Application: SSI 7485

I write regarding the proposed modification to M4-M5 Link, Mod 2 The Crescent overpass and changes to pedestrian infrastructure in North Annandale, Rozelle and Rozelle Bay Foreshore area.

Figure 4-2 Pedestrian and cyclist bridge infrastructure options

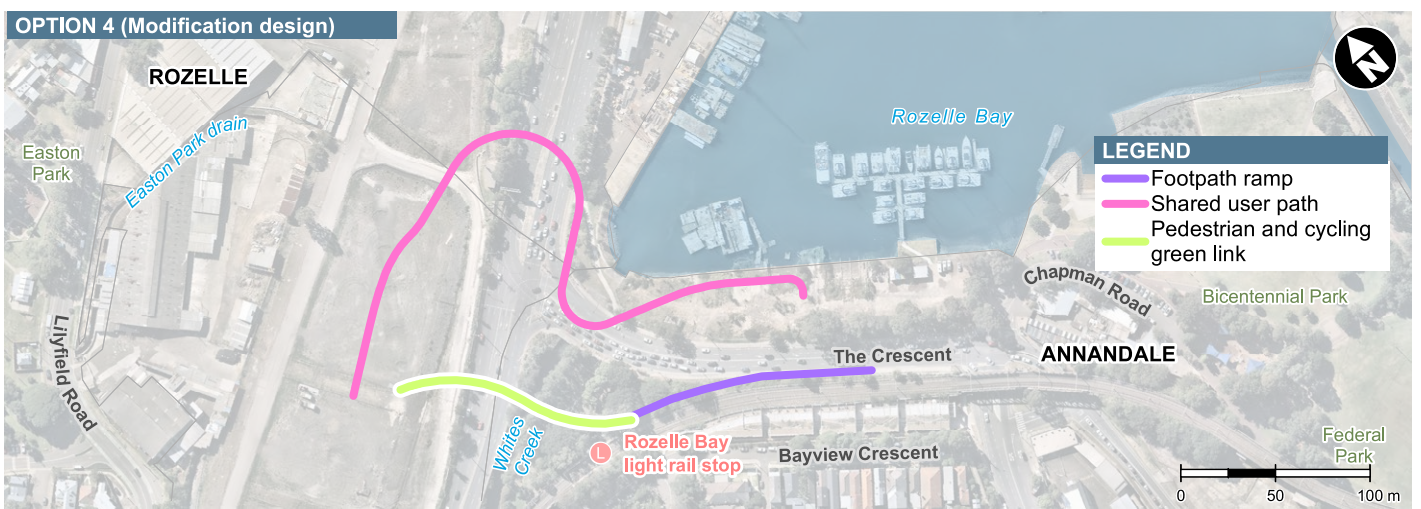
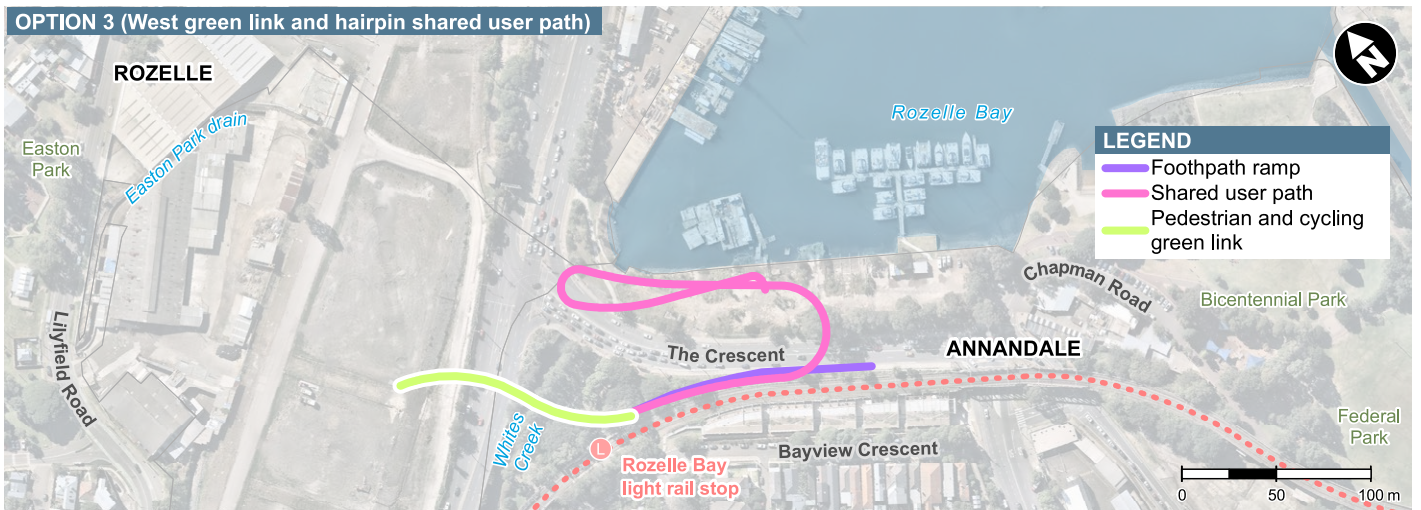
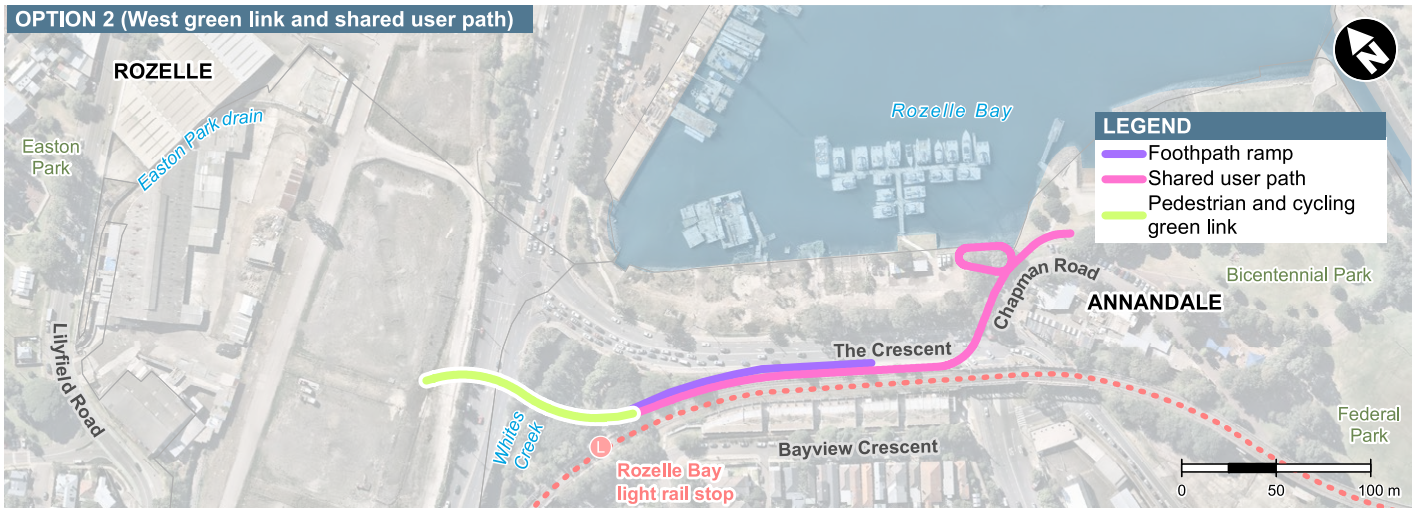
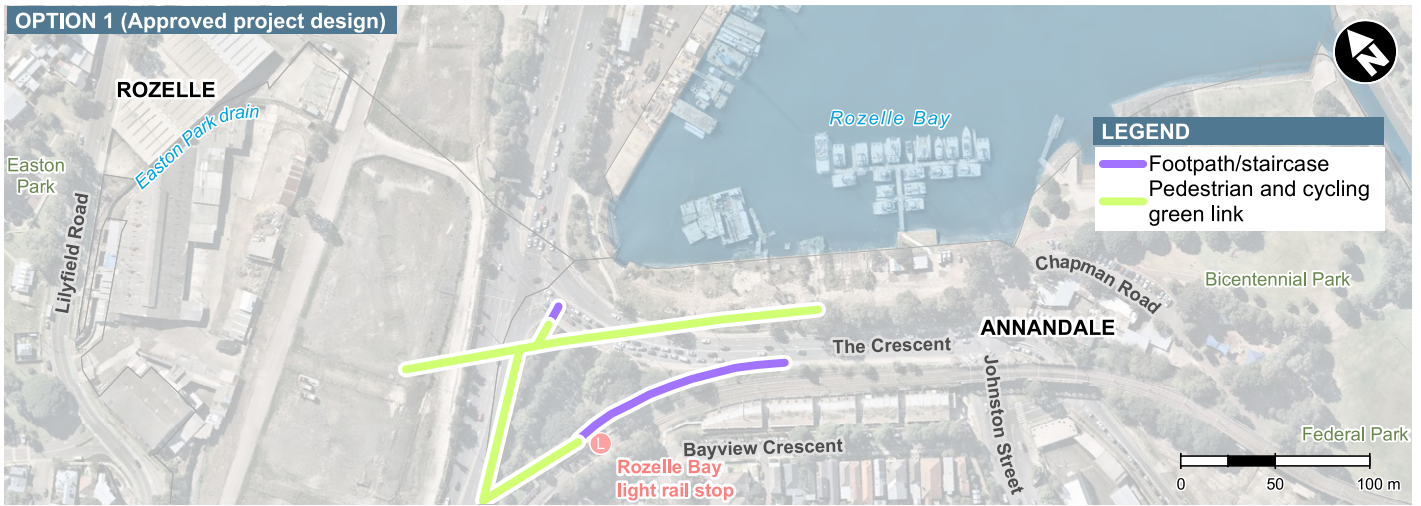
I request that RMS work with the community to explore alternate design options to the proposed new car overpass design and the changed pedestrian and cyclist links. I am seeking the reinstatement of the safe, direct access from the approved EIS GreenLink to create a continuous green open space connection from the Rozelle Rail yards and Annandale to the foreshore. The GreenLink was more than just a walk way - it put people central to the design, maximising safety, and providing much needed accessible open space for the community now and into the future Bays Precinct design.

- The significantly reduced safety and increased risk for pedestrians and cyclists with removed access over The Crescent to Bicentennial Park and the increased traffic along Johnson Street.

Figure 4-3 The Crescent, Johnston Street, Chapman Road intersection options

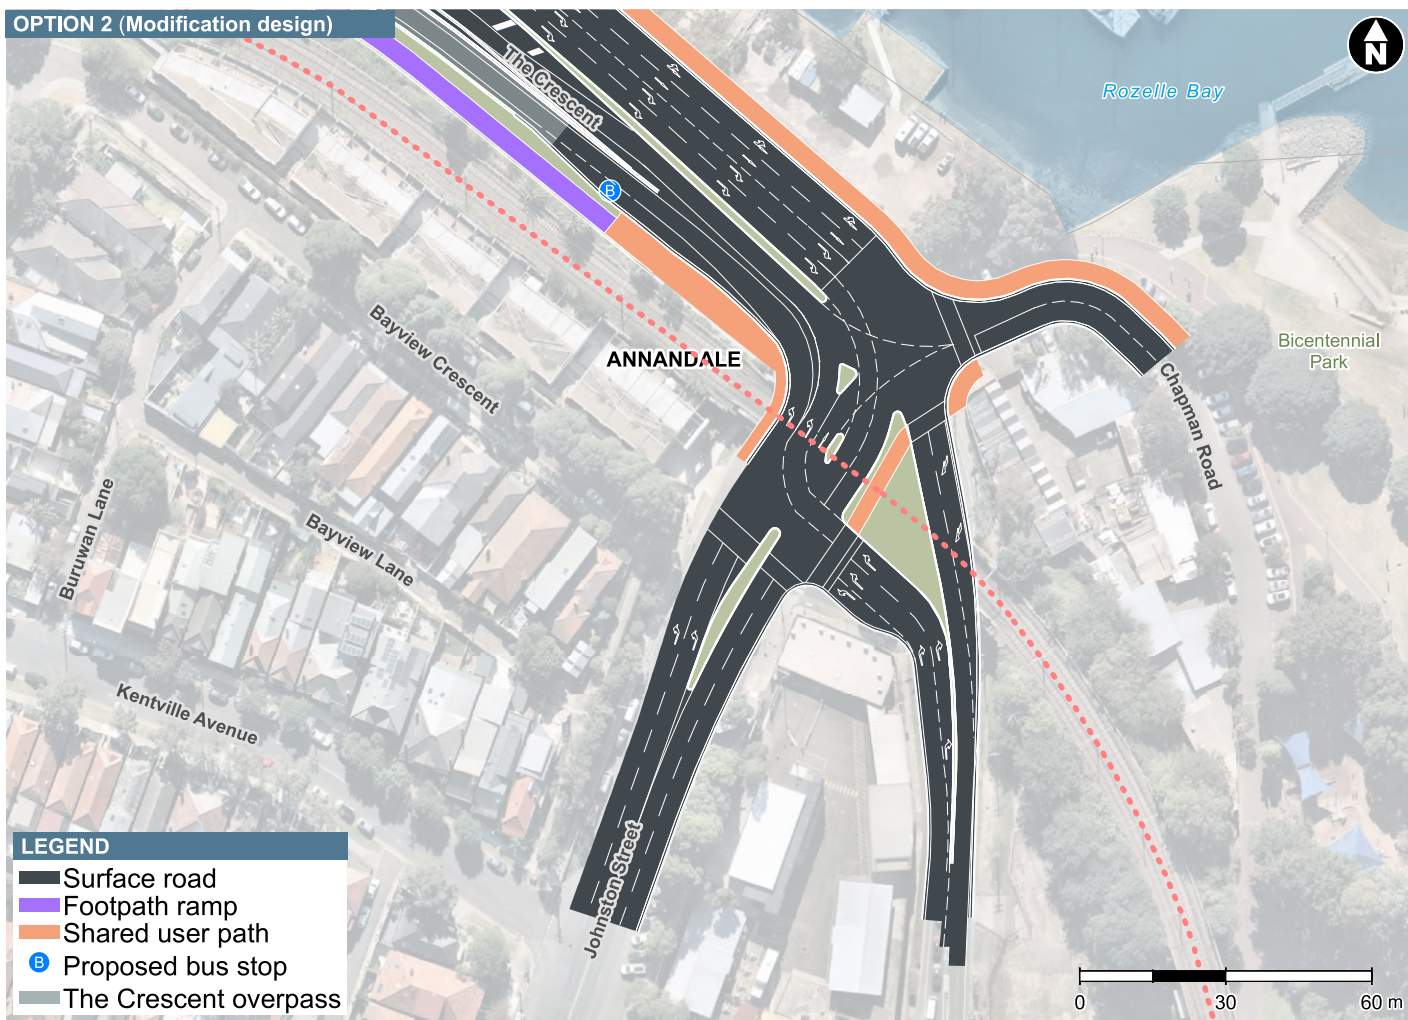
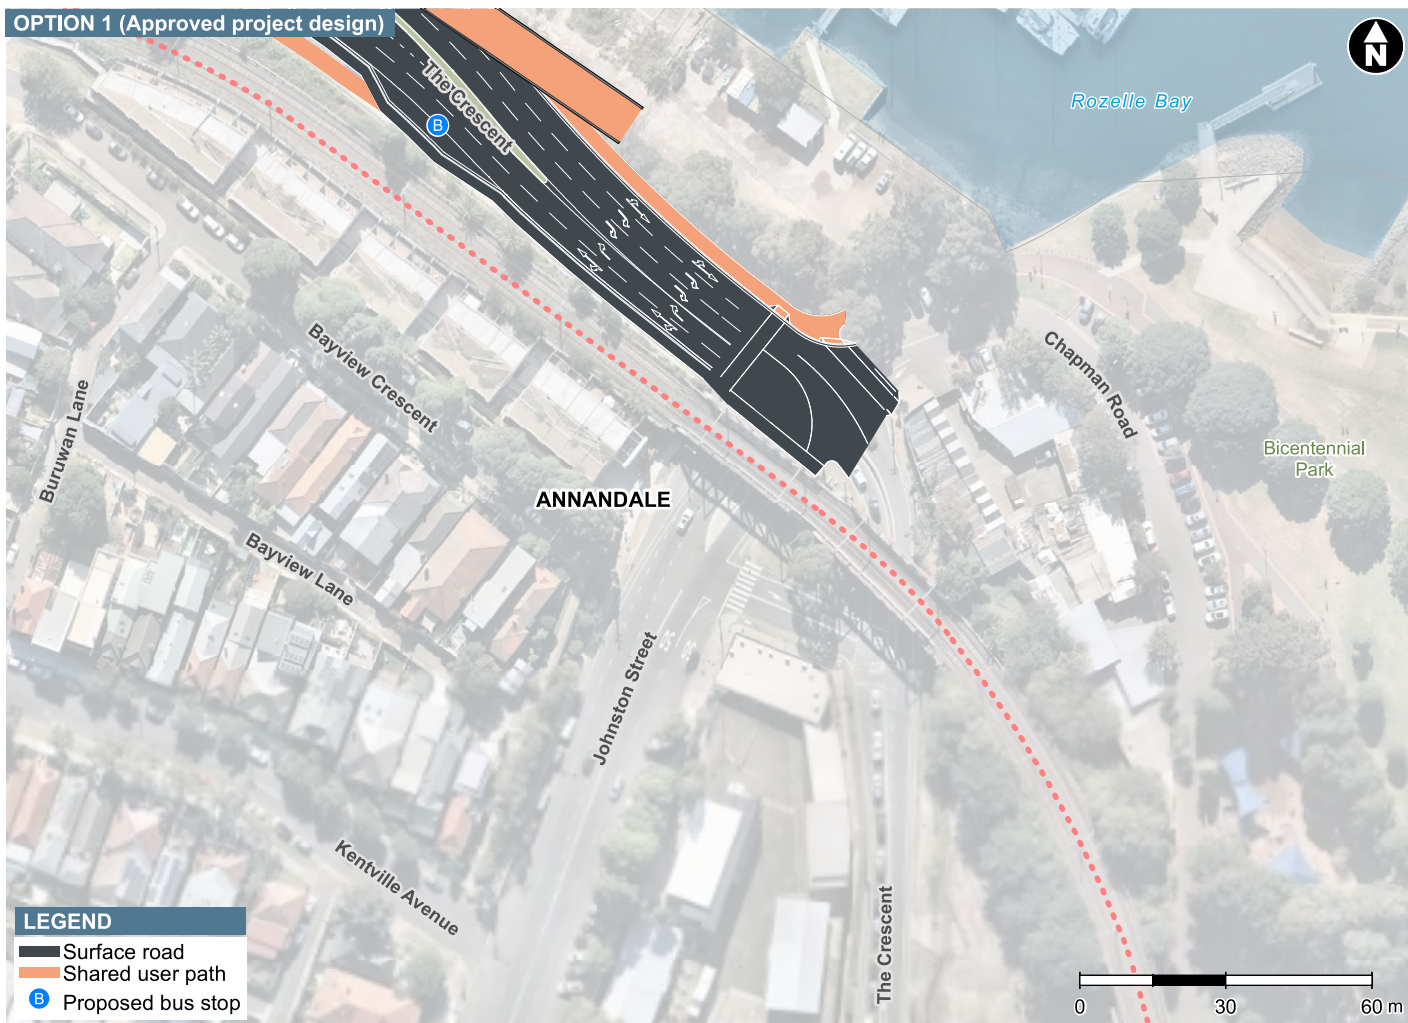
- Being required to cross five sets of pedestrian lights at The Crescent as my option to reach the foreshore from Annandale or from Rozelle Bay light rail stop.
